## **Development Facilitation Team (DHO) – Review Comments**

**Project No: PR-2018-001579   Date: 6/26/2024   Agenda Item: #2   Zone Atlas Page: J-19**

**Legal Description: TRACT E-1-A, Winrock Center Addition (MX-M)**

### **Application For: SD-2024-00112 – Preliminary/Final Plat**

**CONCEPTUAL UTILITY PLAN**

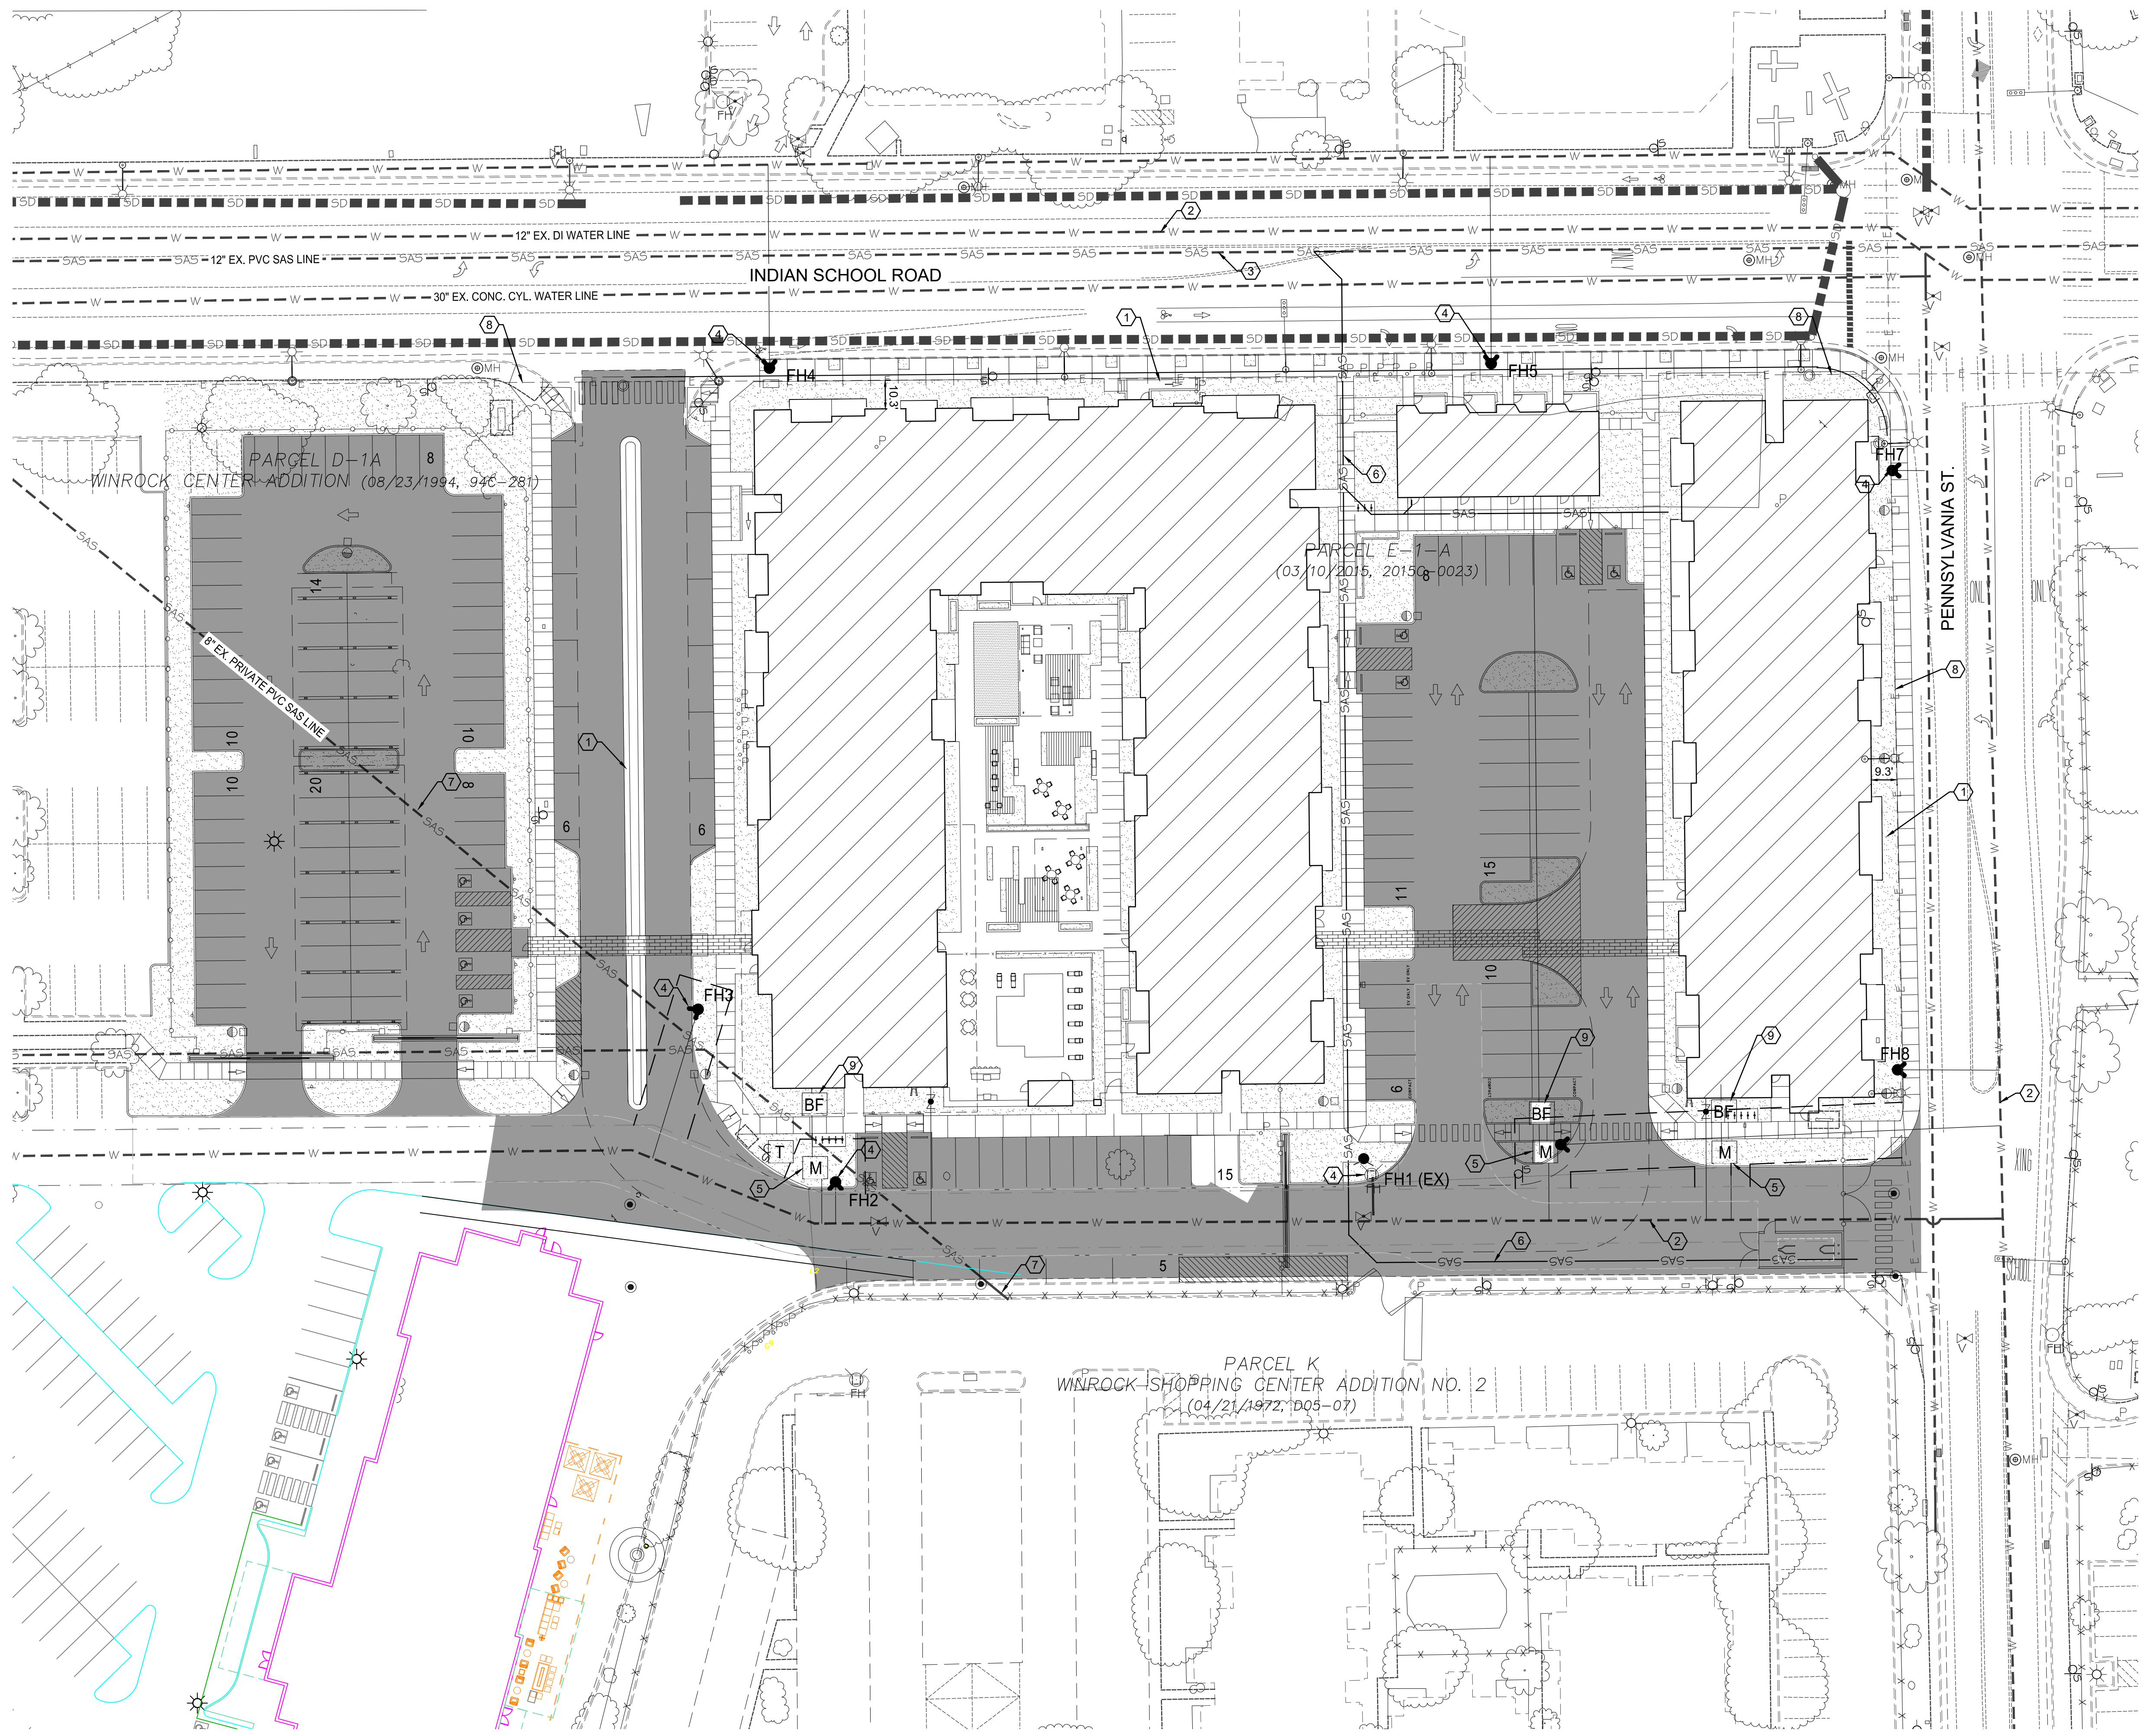
1. Please provide a utility plan for review to ensure the proposed waterline easements will accommodate the necessary infrastructure to serve the site.
  - a. If easements can be coordinated outside of the meeting, this can be approved with the condition that easements are adjusted to accommodate the proposed infrastructure on the utility plan provided.

**PRELIMINARY PLAT  
 PARCEL E-1-A  
 WINROCK CENTER ADDITION**

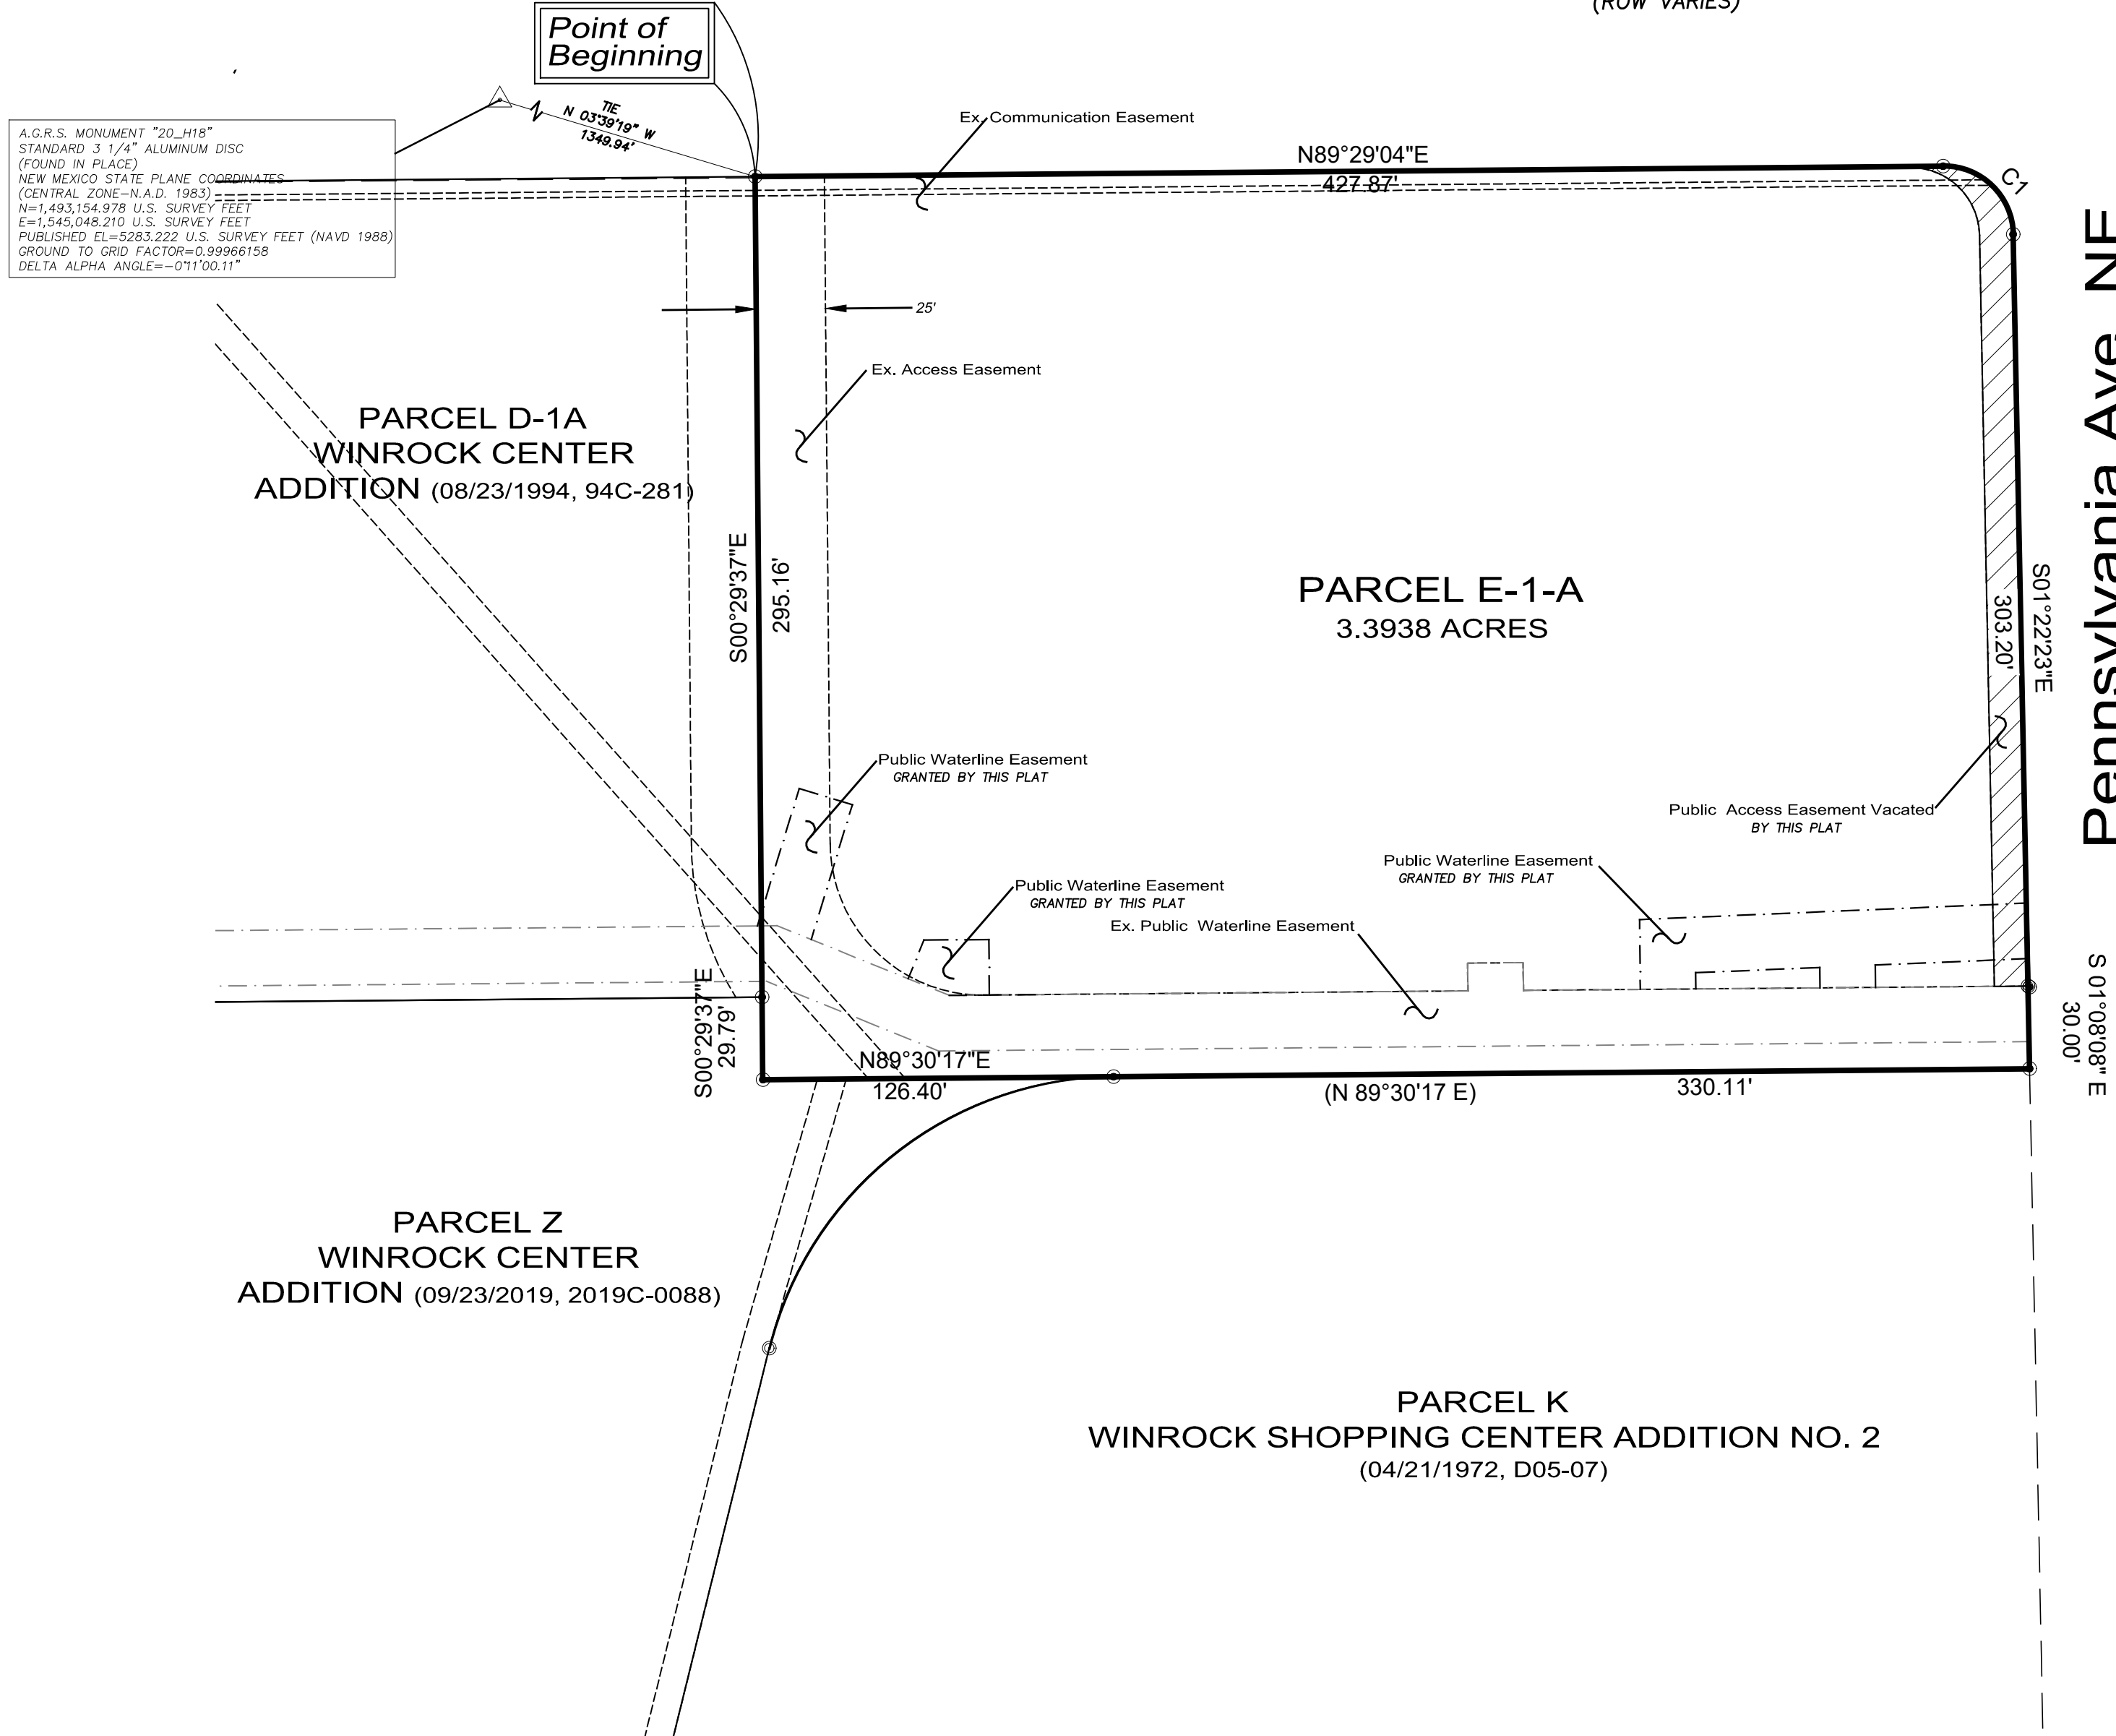
Additionally, during the review of the current platting application, staff noticed that the parcel number on that Plat has not been changed from “Parcel E-1-A” to another number to note the replat; for example, the new parcel number might be changed to “Parcel E-1-A-1.” **Planning staff recommend that as a condition of approval of the current Plat, a Minor Amendment to the Preliminary/Final Plat for PR-2018-001579 / SD-2021-00073 be submitted for DHO review and approval to revise the number of the replatted parcel from “Parcel E-1-A,” the conditions of approval for PR-2018-001579 / SD-2021-00073 be addressed/met (such as addressing ABCWUA comments), and the Plat recorded.** Alternatively, the Applicant could choose to withdraw the Plat for PR-2018-001579 / SD-2021-00073 and re-apply for the Vacation of a Public Access Easement for a deceleration lane along Pennsylvania Street NE for DHO review and approval.

- This Plat depicts the vacation of a private access easement along the southern boundary of the subject property; while noted in the October 18<sup>th</sup>, 2023 Sketch Plat previously reviewed by DFT staff, a separate Vacation application has not been submitted to and approved by the DHO (or DRB previously). Therefore, **prior to the approval of this Plat, a Vacation of Private Easement application for the noted private access easement must be submitted and approved by the DHO** (could be approved concurrently with this platting application).

- The project and application numbers for the Plat must be corrected.
- The parcel number created by this replat must be revised to accommodate the previous replat for PR-2018-001579 / SD-2021-00073 as well as the current replat.
